**Jeanie Bourke - Re: Fwd: Urban Farm Fermentory renovation: Amendment To Permit 2014-00580, 200 Anderson St**

**From:** urban farm fermentory <[urbanfarmfermentory@gmail.com](mailto:urbanfarmfermentory@gmail.com)>  
**To:** Jeanie Bourke <[JMB@portlandmaine.gov](mailto:JMB@portlandmaine.gov)>  
**Date:** 5/1/2015 5:04 PM  
**Subject:** Re: Fwd: Urban Farm Fermentory renovation: Amendment To Permit 2014-00580, 200 Anderson St

Yes, I did see that the permit has been moved forward in the process. I have just started looking at the plans. While amendments are eligible for fast track, we do have discretion to review any application, as is the case with this one. The fire department will also review. In any event, the review is commencing out of order. I do have some initial comments, first for zoning.

Drawing file: 4. Revised Plans / Plan A-0.1 Key Plan & Occupancy.PDF

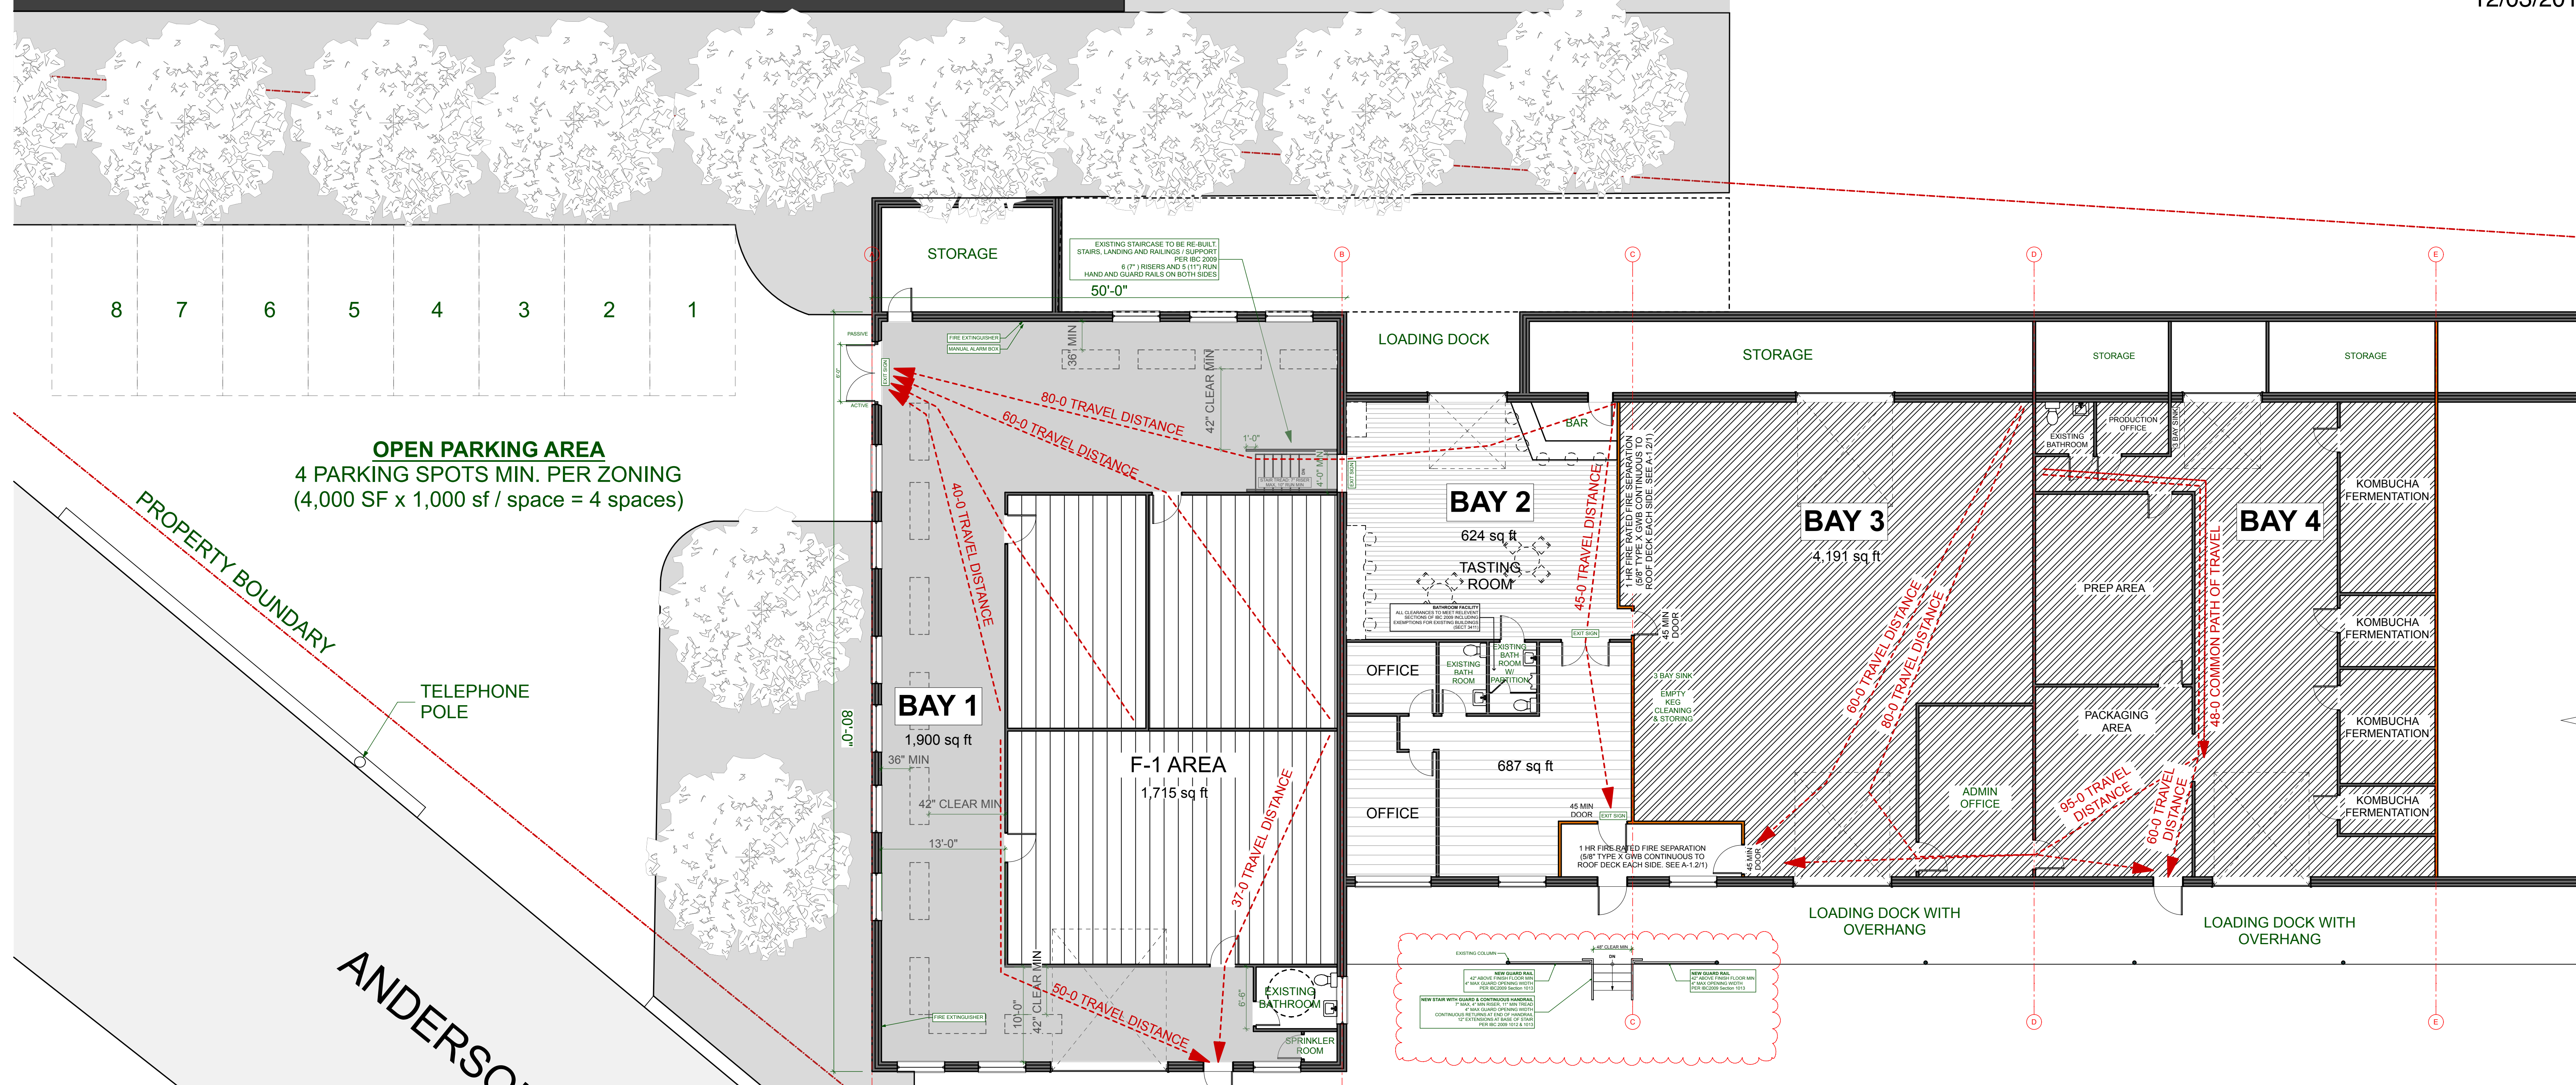
The previous tasting room was quite modest in comparison to this new area. In the previous permit approval the zoning use was included on the proposed floor plan in line with the II permitted uses. Please provide a zoning use note box on the proposed plan with this language, including the intent of the tasting room. Is it purely for "tastes", or are you planning to sell product to be consumed on premises. What needs to be clarified is that this is not intended to be a drinking establishment.
